Application No: R/222/21/HH
Site Address: 42 Pigeonhouse Lane Rustington BN16 2BE
Description of works: Single storey rear extension and hip to gable loft conversion with 2 x dormers following the demolition of existing rear conservatory

Thank you for your internet representation made on 14th October 2021 which has been recorded as an objection with the comments as follows:

:: Proposed South Elevation

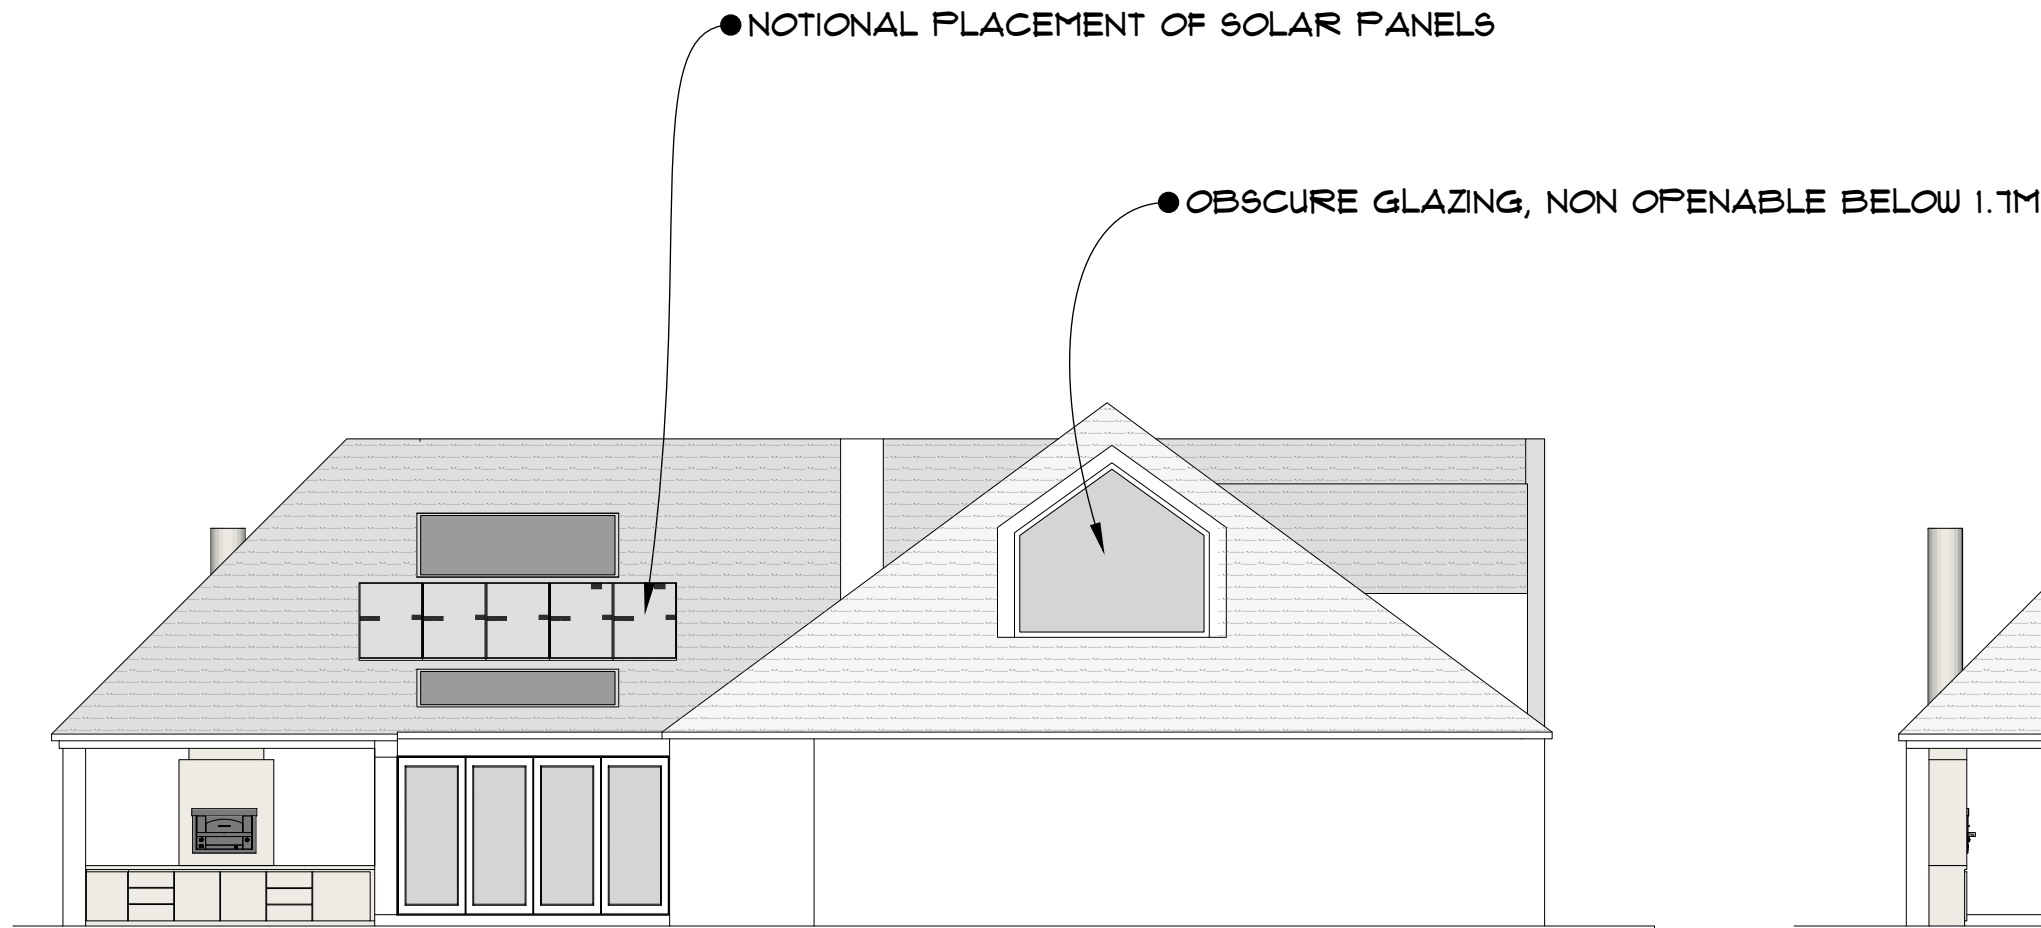
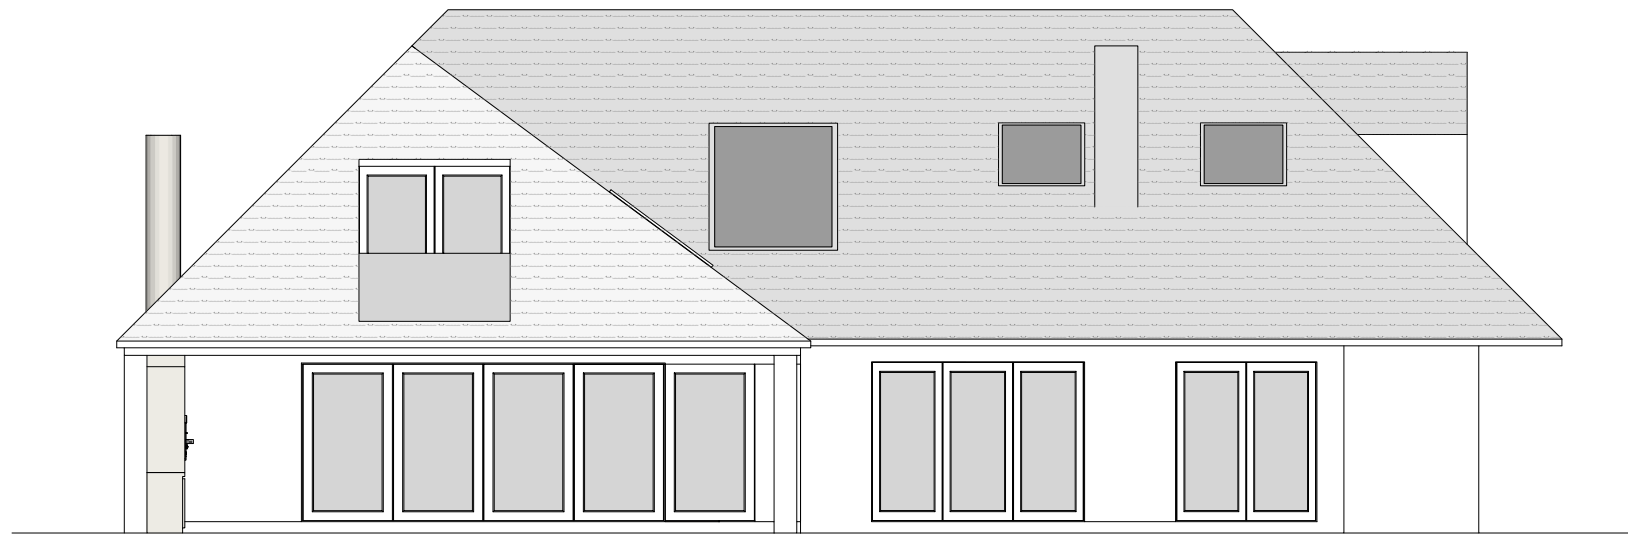
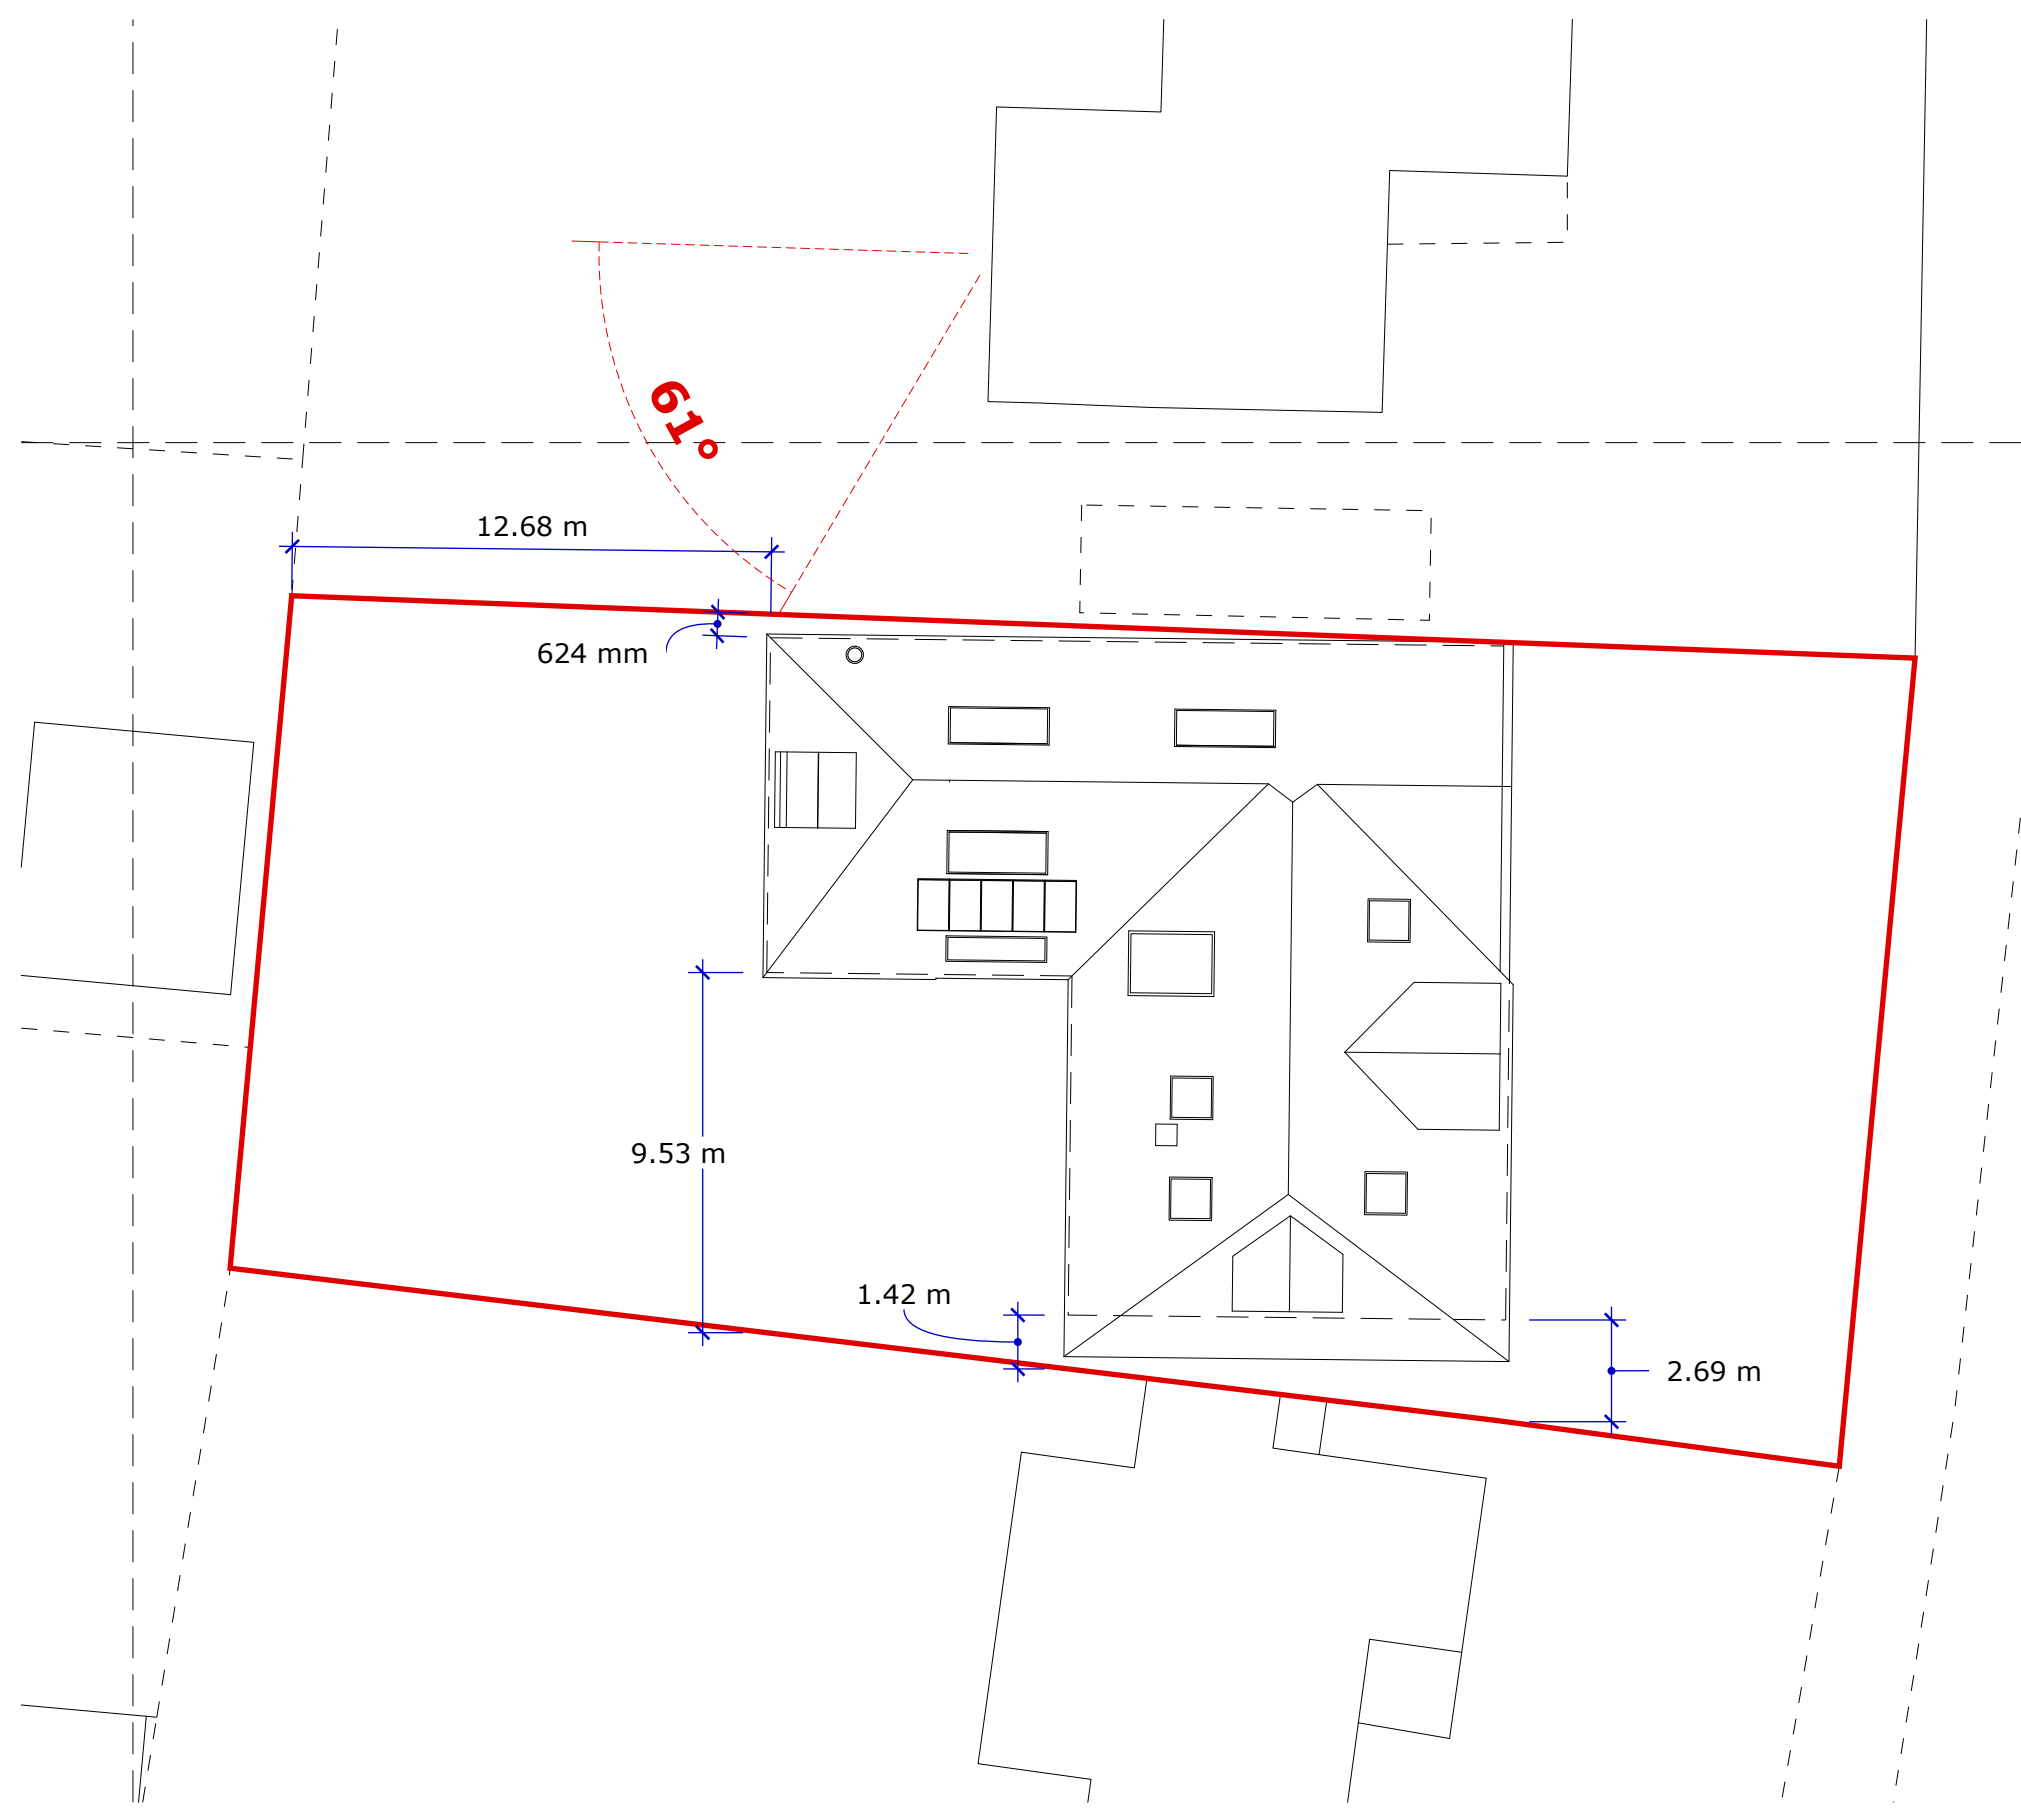
The first floor Dormer on South roof elevation when in isolation is not an issue however when taking into consideration our property to South which has a tiled gabled Dormer currently facing out to the South roof elevation of the applicants property the new Dormer would appear over bearing and disjointed. We would have no objection to a Velux style Roof Window which would in our opinion be more appropriate for a bathroom set within a pitched hipped roof and ultimately be less obtrusive.
